Final Review Comments for 169 Newbury St - Luminato

Re: 169 Newbury St – Luminato Condominiums

5 CATCHBASIN #2 SECTION (II-2)
NOT TO SCALE

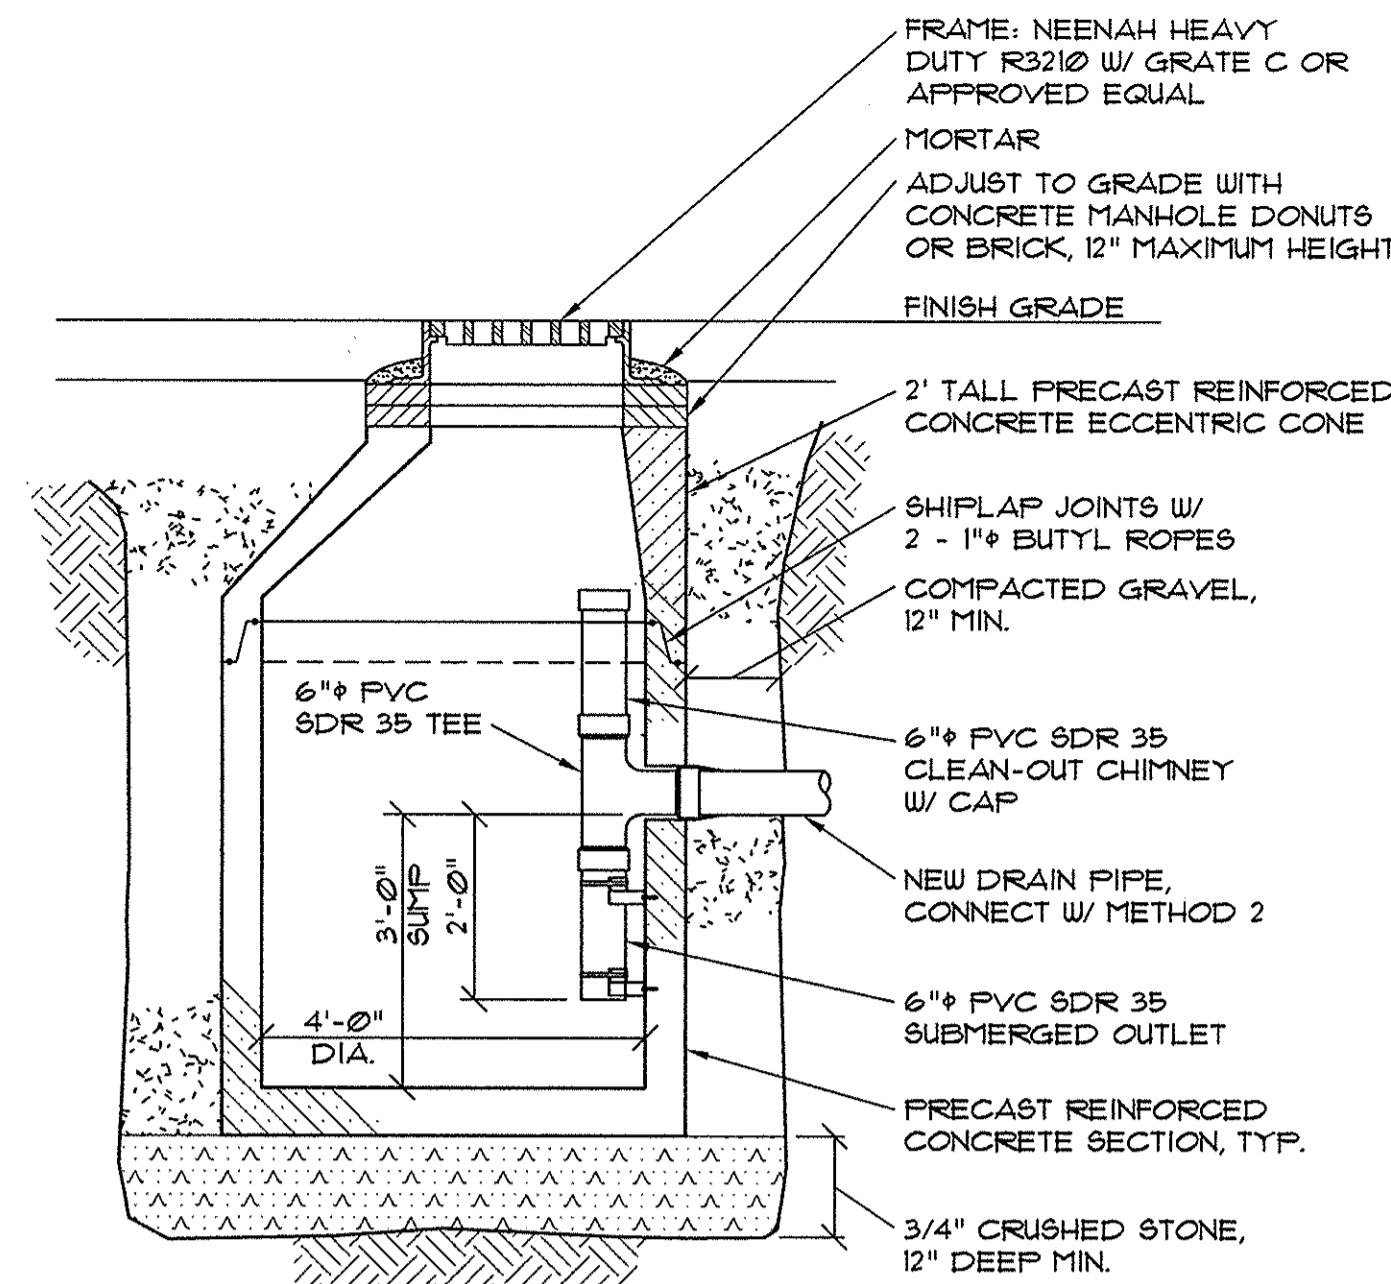
4. It is understood that all roof and site drainage will be directed to proposed catchbasin #2 in Newbury St. or to the ground and not the sanitary sewer system. Please confirm that this is the case. Please note that N-12 is not permitted within the street right of way. Please consult Chapter Two of the City's Technical Manual for acceptable pipe material options.

7. An oil/grit separator will be required within the parking garage on both levels. Modifying the proposed catchbasin to include a three foot sump and down turned 90 degree bend to allow for one foot of oil capture is acceptable. Please show detail and indicate oil/grit locations on plans. Please keep the sanitary lateral connections downstream of the oil/grit separators and change the designation of the line from SD leading to the City's sanitary sewer.

All site drainage will be conveyed to Hampshire St and N-12 will not be used.

This issue has been addressed.

8 TYPICAL BACKFLOW PREVENTOR DETAIL
NOT TO SCALE

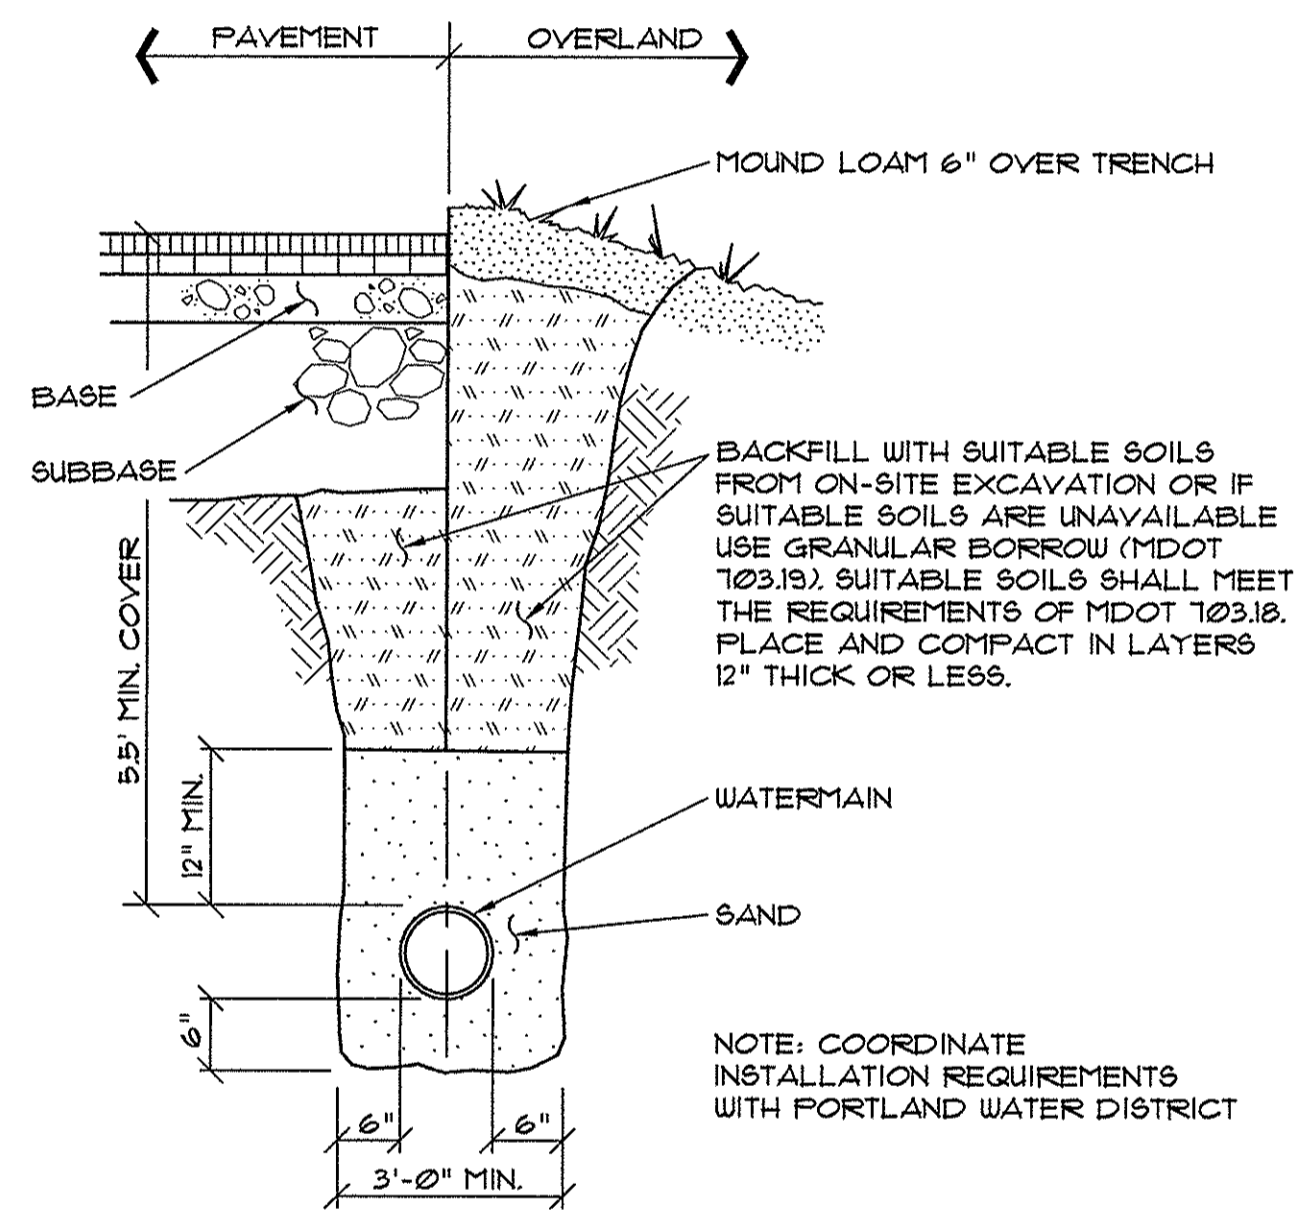
8. Since the sewer systems are separated, a backflow preventer on the sanitary lateral is not required by the city. If the applicant wishes to install one, please place the backflow preventer on the applicant's property.

Issued resolved. The backflow preventer has be eliminated.

**5 BITUMINOUS DRIVEWAY APRON (I-13)**  
NOT TO SCALE

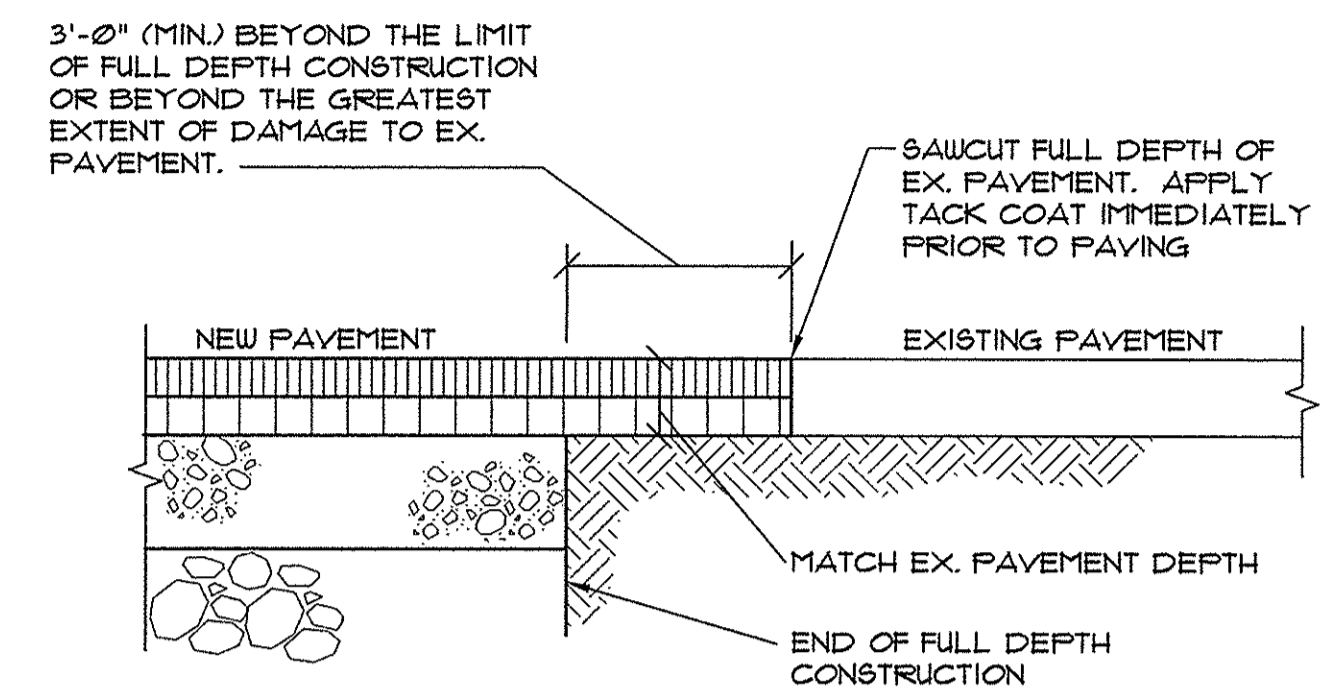
5. The applicant is showing a brick driveway apron within the street right of way on Newbury St.

This is a deviation of the City's material policy which calls for an asphalt apron. This department is supportive of a waiver request however the applicant will need Council approval and signoff on maintenance agreement of the drive apron within the road right of way.

Drive aprons have been changed to asphalt.
